Stantec Architecture Inc.
722 12th Street NW Suite 100, Washington DC 20005-3957

October 21, 2022

Reference: New Mexico Proton Advanced Cancer Therapy (NMPACT)
Response to Development Review Board Comments
Project: PR-2022-007588
Application: SI-2022-01658

NEW MEXICO CANCER CENTER
4901 LANG AVE. NE
ALBUQUERQUE, NM 87109
Title
BUILDING ELEVATIONS

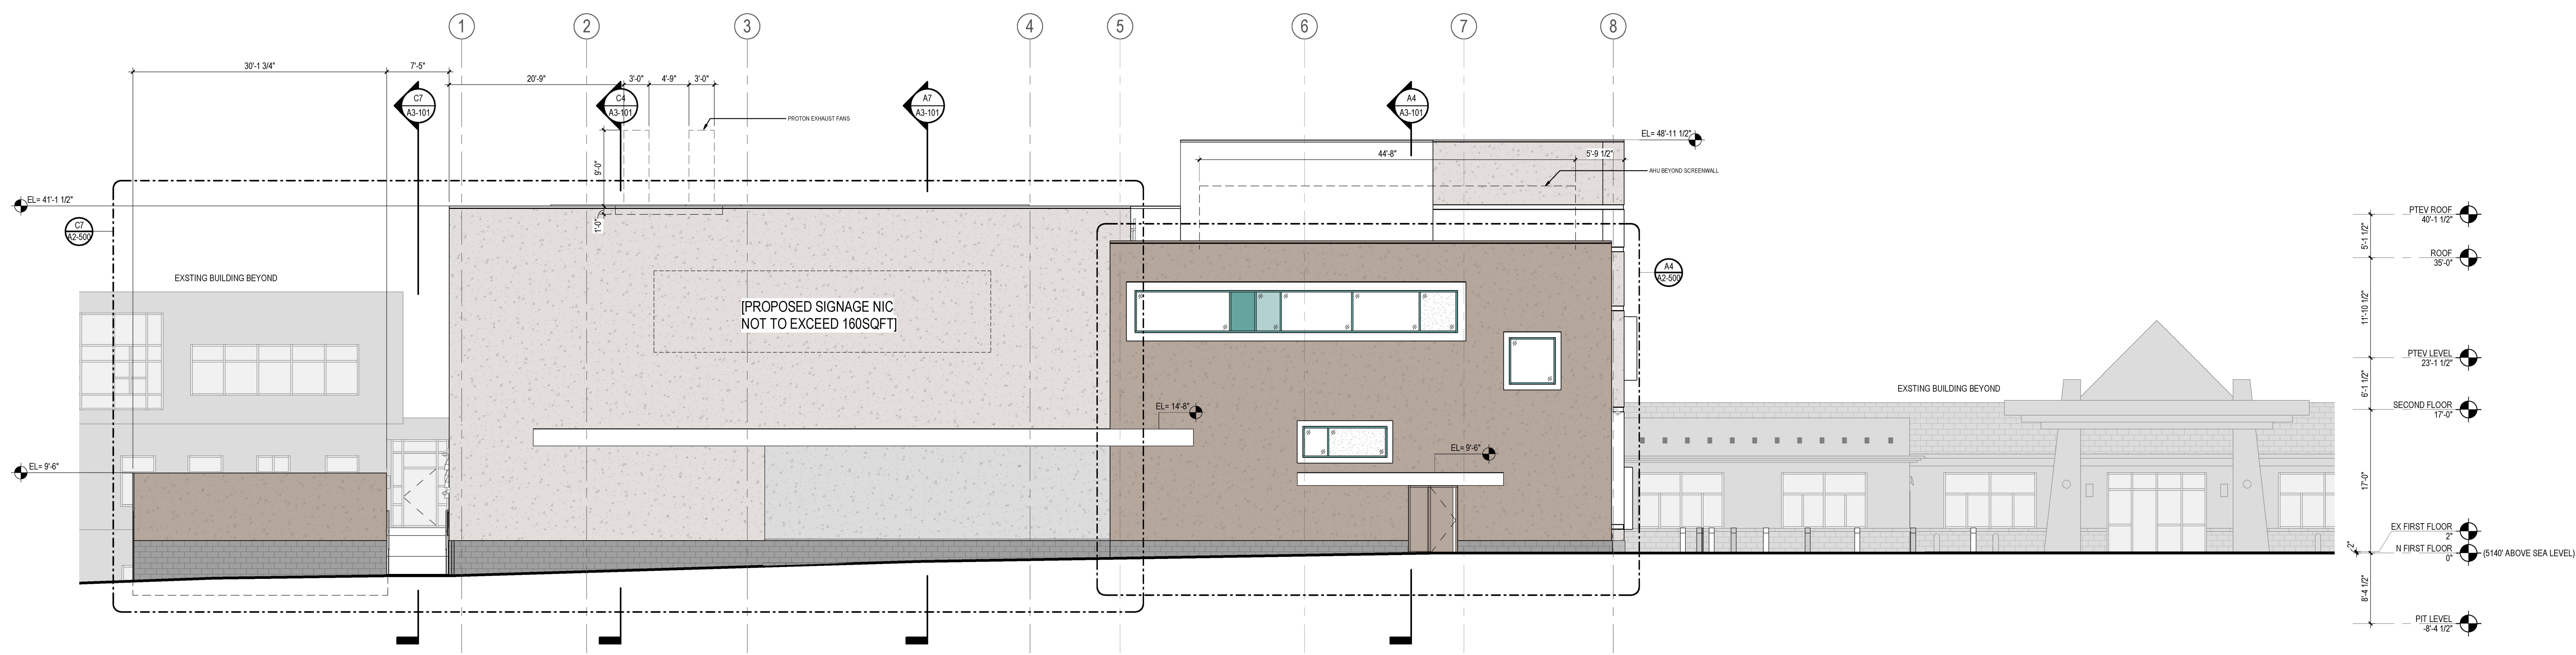
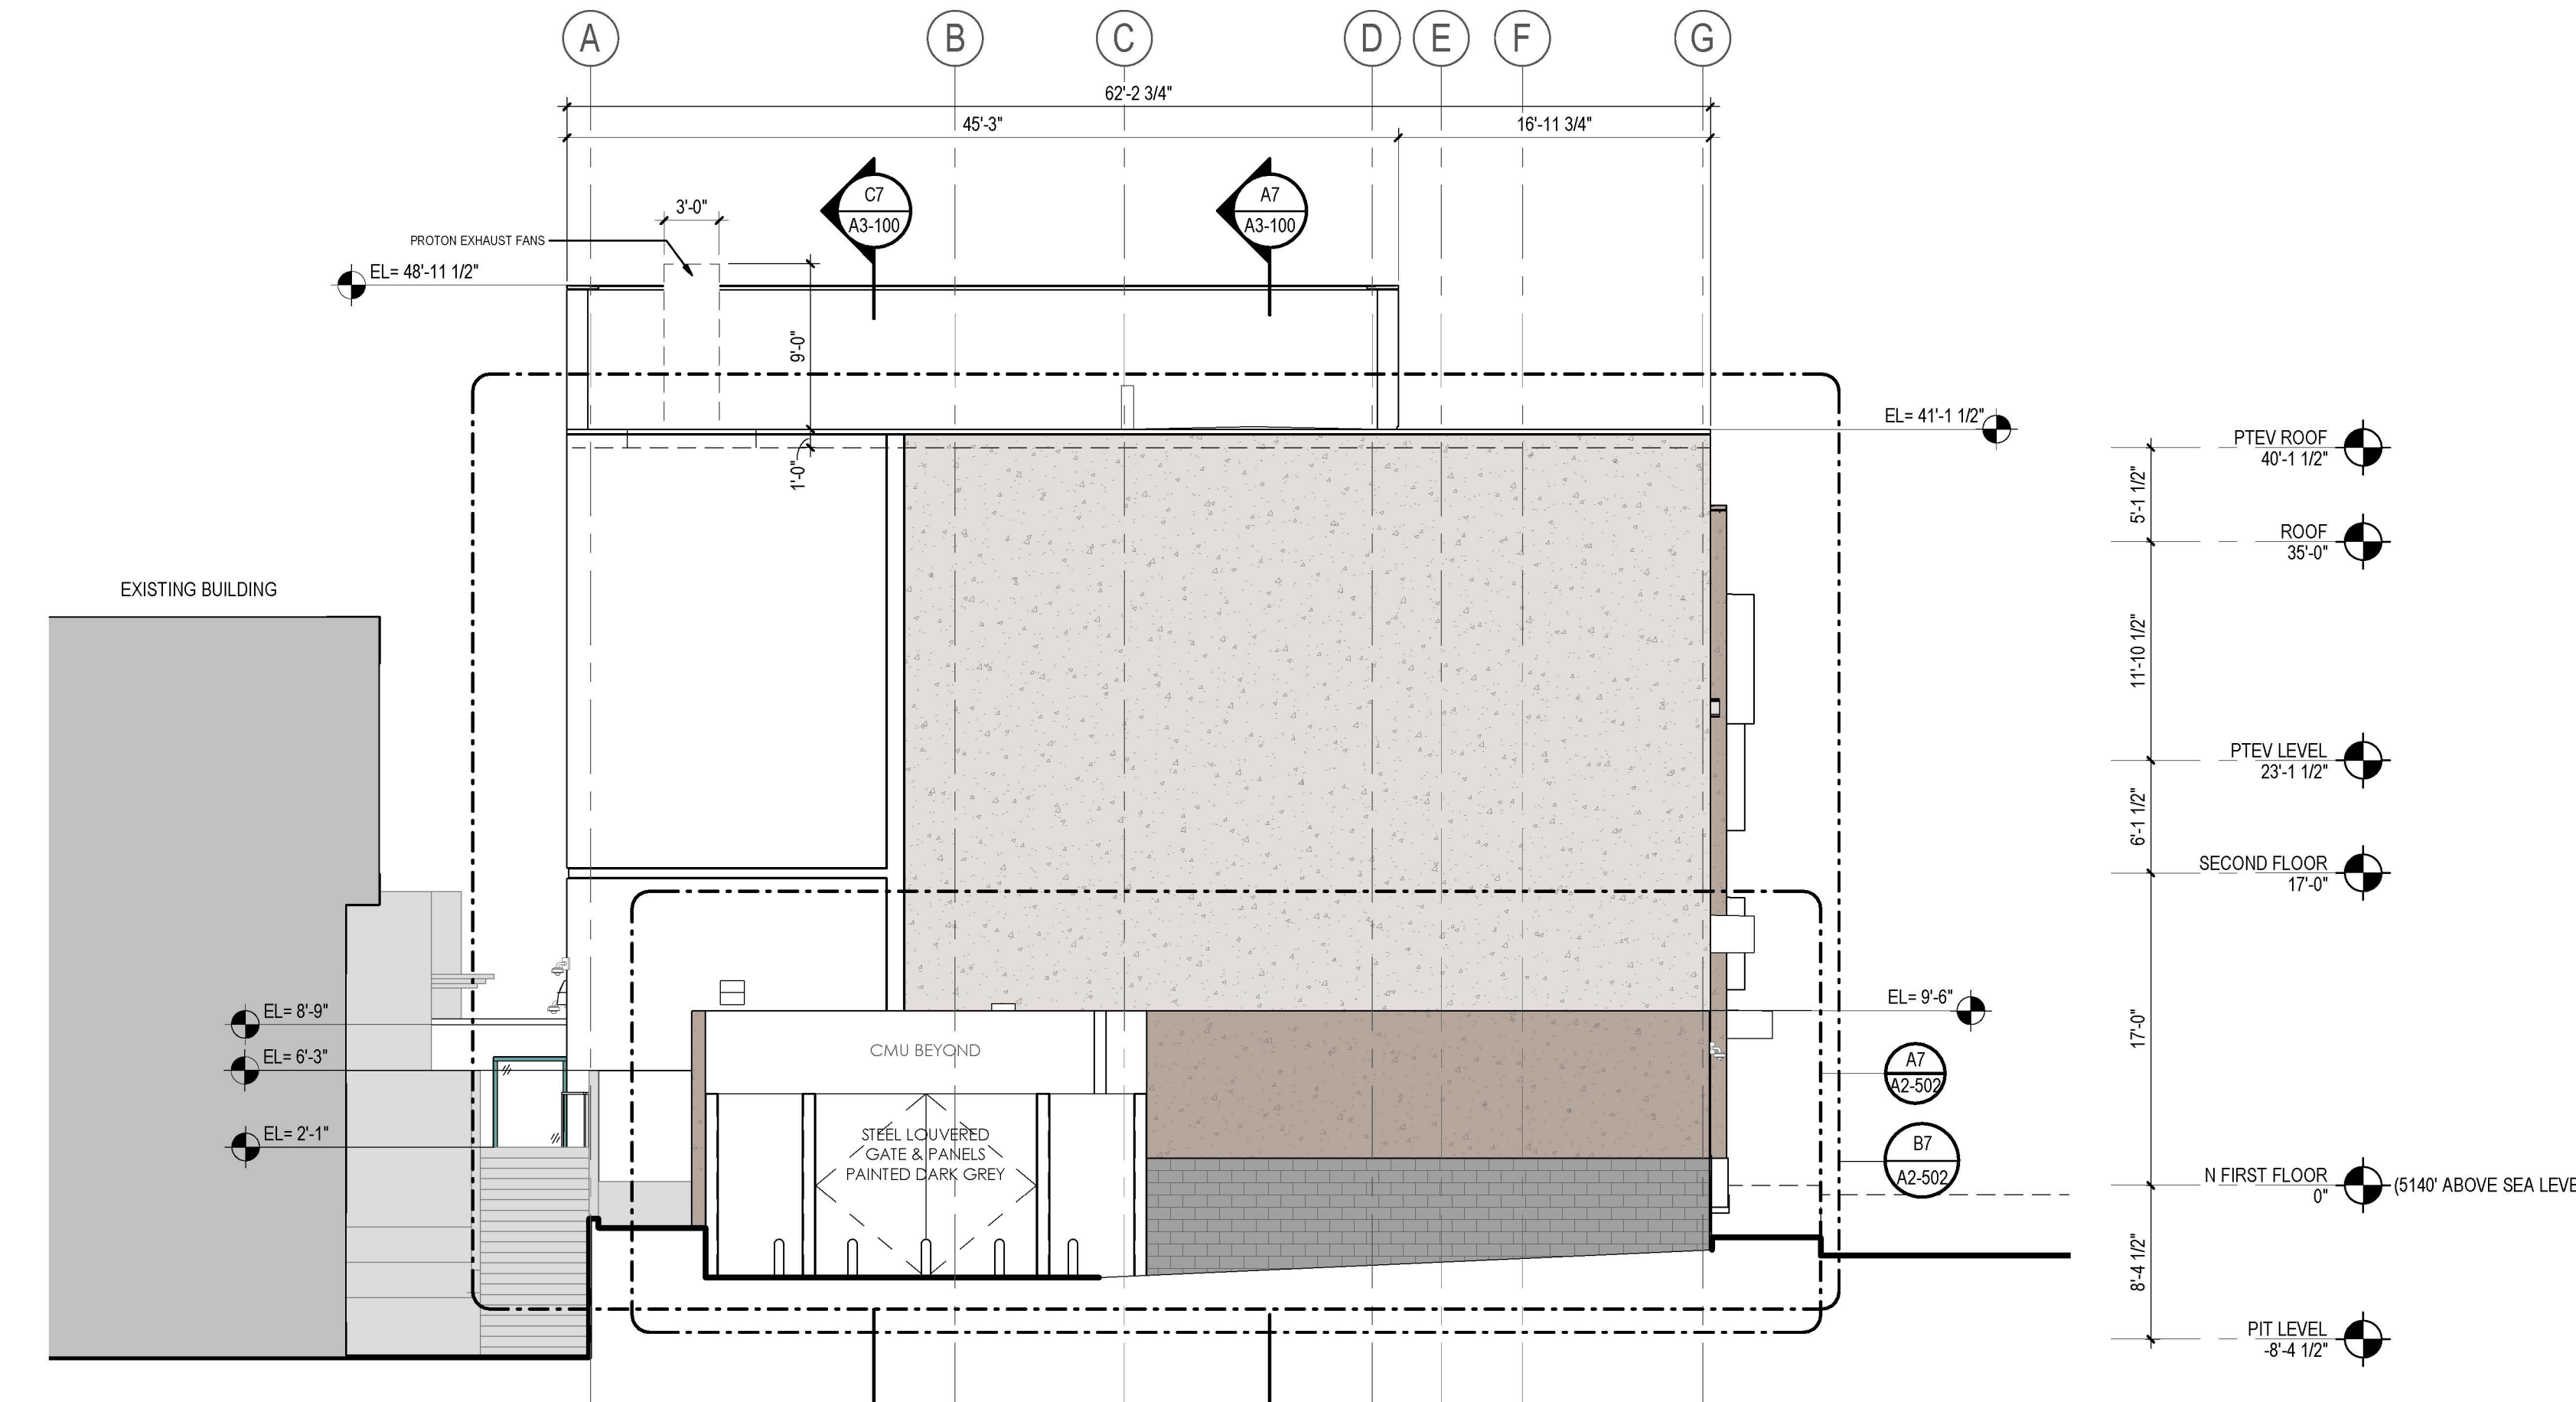
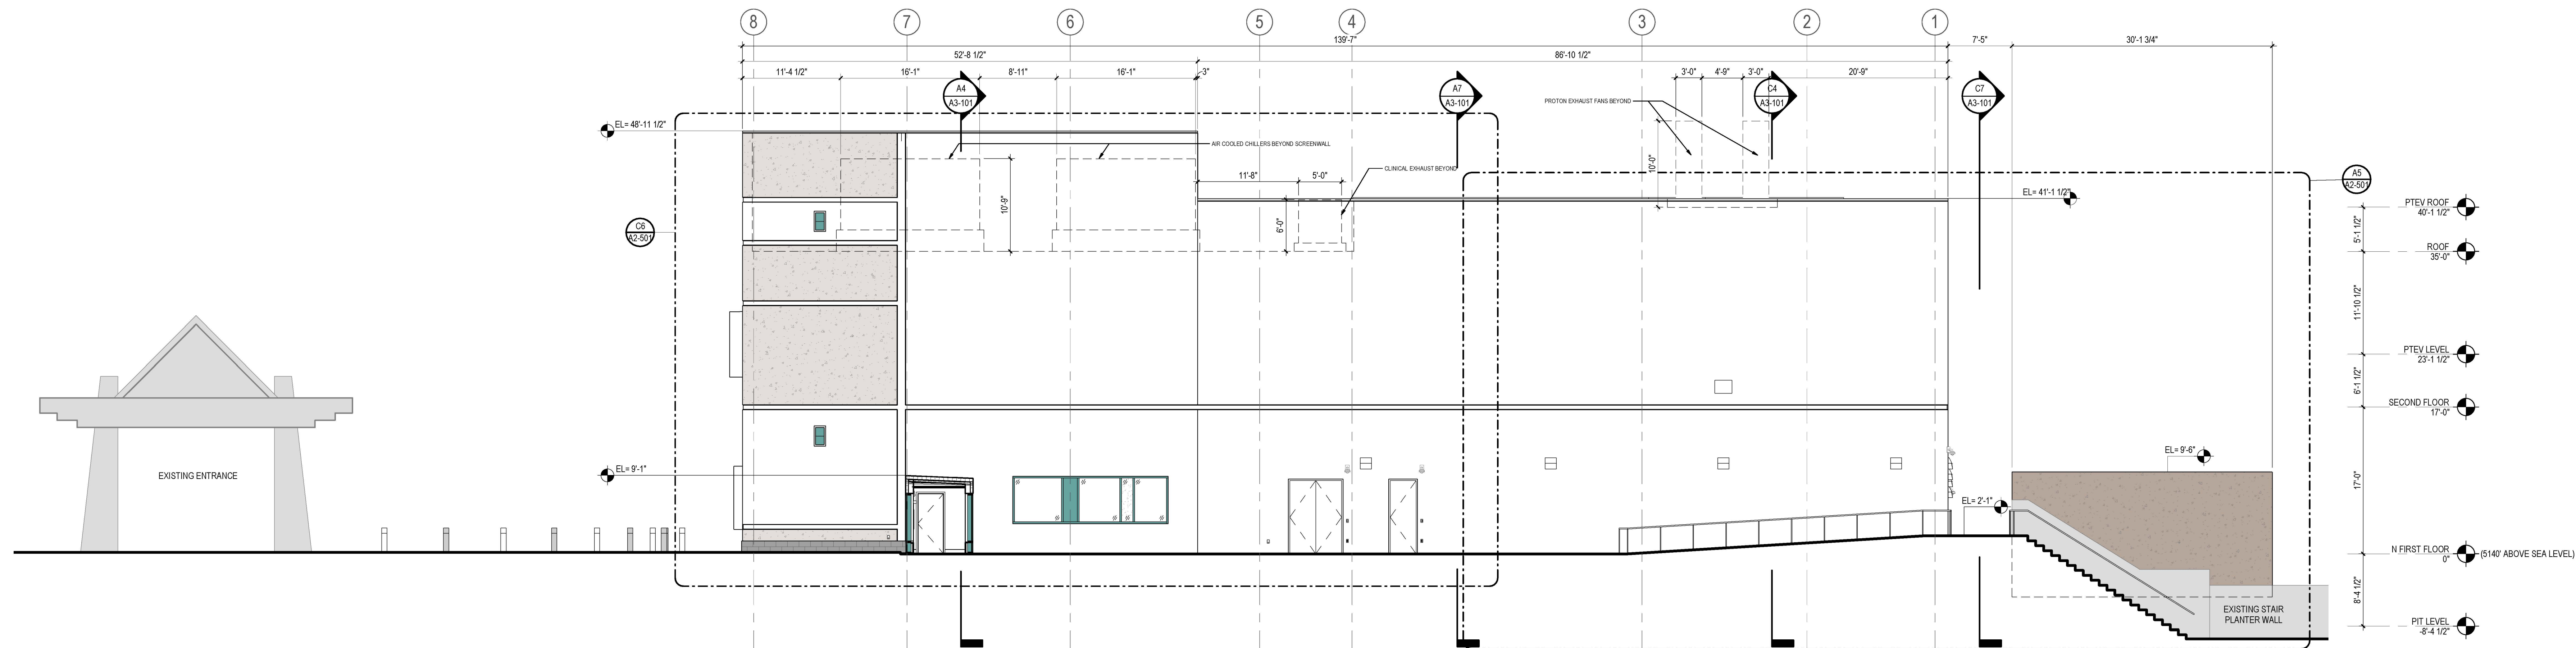
- a. *Stantec Response: Please confirm that the compliance issue is the same one identified below in Planning comment 3.*
3. The applicant must provide proof how the building/façade design requirements are being met per 5-11(E) of the IDO as notes on the amended Site Plan and/or in a comment response letter.

- a. *Stantec Response: The project complies with relevant sections of 14-16-5-11(E). Under 5-11 (E)(2) Façade Design:*
 - i. *5-11 (E)(2)(a)(1). The south and east facades provide a sense of human scale at the ground floor with unique base material, sunshades, offset in wall plane, and large bank of glazing. See attached project rendering.*

- ii. *5-11 (E)(2)(a)(2). The street-facing façade (south elevation) incorporates two features. Specifically:*
 1. *Item (b). Windows on upper floor. There are two windows on the second floor and their combined length exceeds 30% of the façade length. The windows combine for 44 feet and the façade is 140 feet. $44/140 = 31\%$ of the façade. See attached project rendering and Building Elevations, Sheet A2-100.*

2. *Item (d). Elements that provide shade or protection from weather. There are two sunshades, and their combined length exceeds 30% of the façade length. The element also occurs more frequently than every 40 feet. The sunshades combine for 100 feet and the façade is 140 feet. $100/140 = 71\%$ of the façade. See attached project rendering and Building Elevations, Sheet A2-100.*

- iii. *5-11 (E)(2)(a)(3). The street-facing façade (south elevation)- longer than 100 feet - incorporates more than one required feature. Specifically:*

1. *Item (c). Offset or projecting element. There is a niche that is 3'6" offset from main façade plane that is 30% of the façade length. Additionally, there are two sunshades that project more than 6" from the façade and cover 71% of the façade. See attached project rendering.*

2. *Item (f). Art. There is an 11-foot high by 42-foot-wide section of the façade (at ground floor) that is designated for an Owner-furnished tile mural. See attached project rendering.*

EXHIBIT A

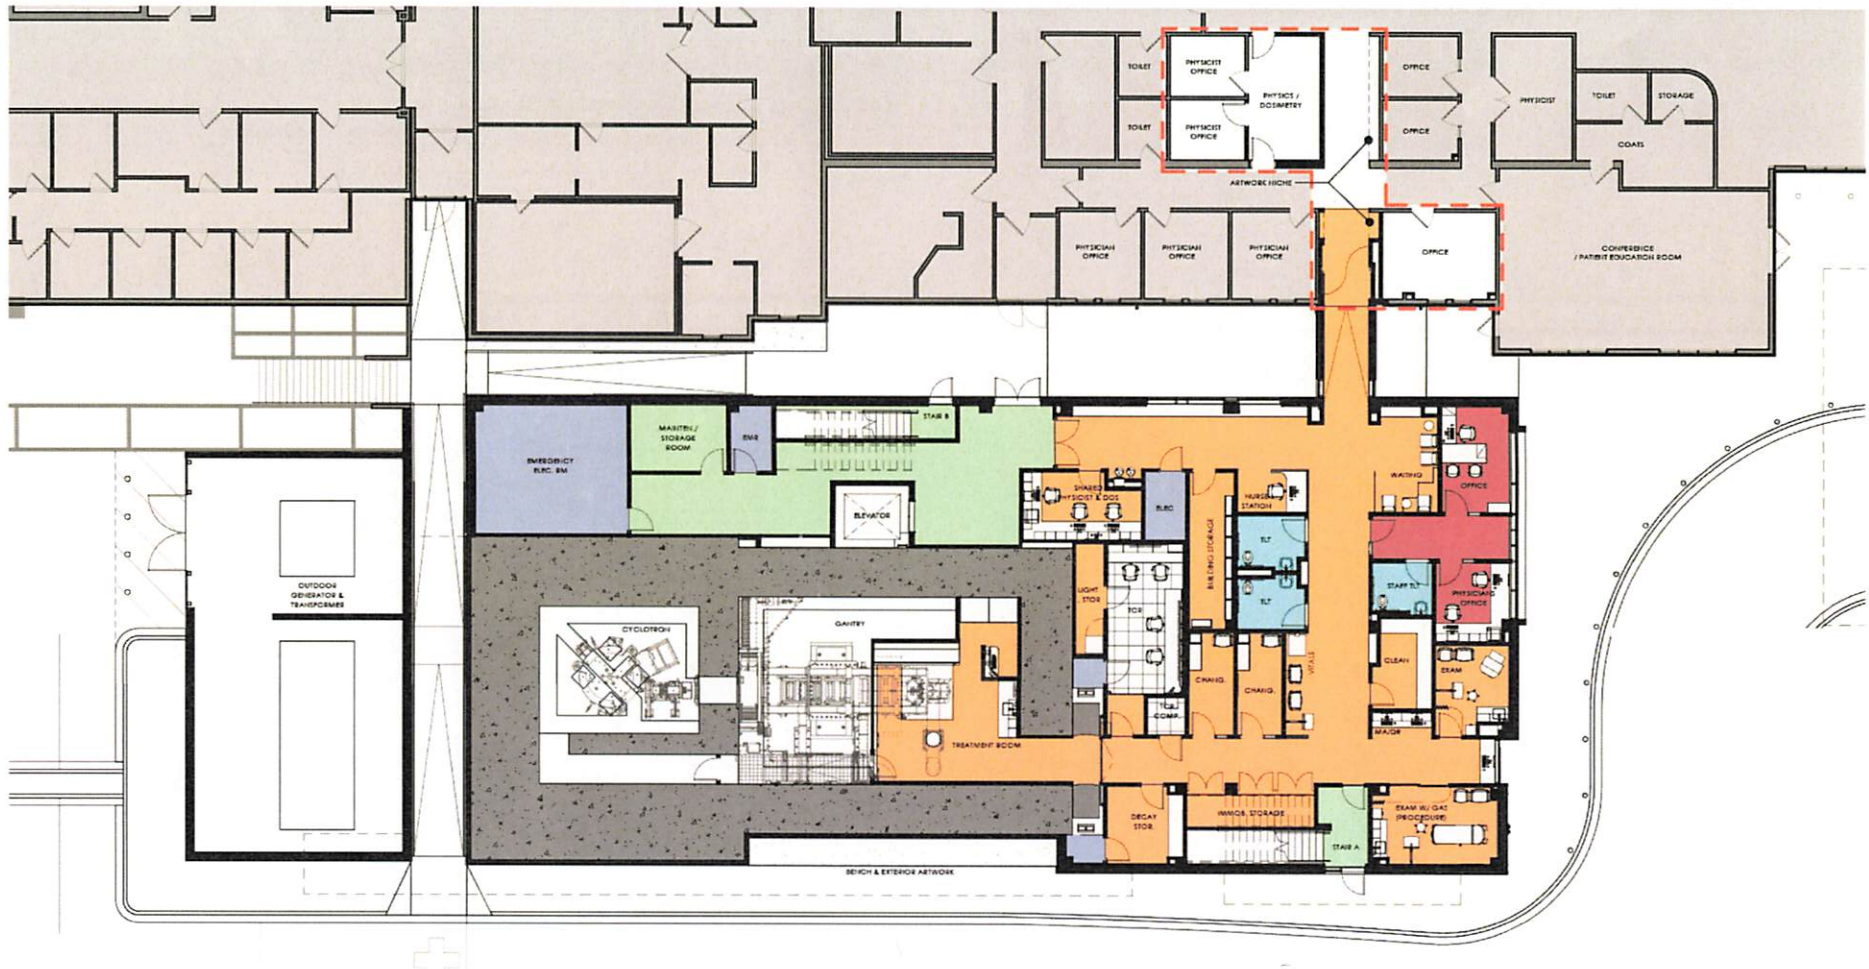
- a. Elaborate on how the additional 14K GFA of the proton center results in the need for only 12 more spaces. Maybe a graphic of the floor plan that shows occupancy. This is a critical component of your analysis and it needs some more explanation and math facts to back it up. (see paragraph below from the Study).
- b. The lease agreement term appears to be for 5 years and it does have a renewability clause. Please help explain how the NM Cancer Center will ensure additional parking when this lease time is set to expire.

- i. *Stantec Response: NMCC has prepared a letter (with exhibits) explaining occupancy and lease duration. The letter is attached.*
7. The Parking Tabulation section of the Site Plan notes that 100 parking spaces will be provided off-site. If any off-site parking spaces will be utilized and will count toward the total of number of required parking spaces, a recorded Shared Parking Agreement will be required for those parking spaces and must be submitted prior to the approval of this Major Site Plan Amendment – DRB.
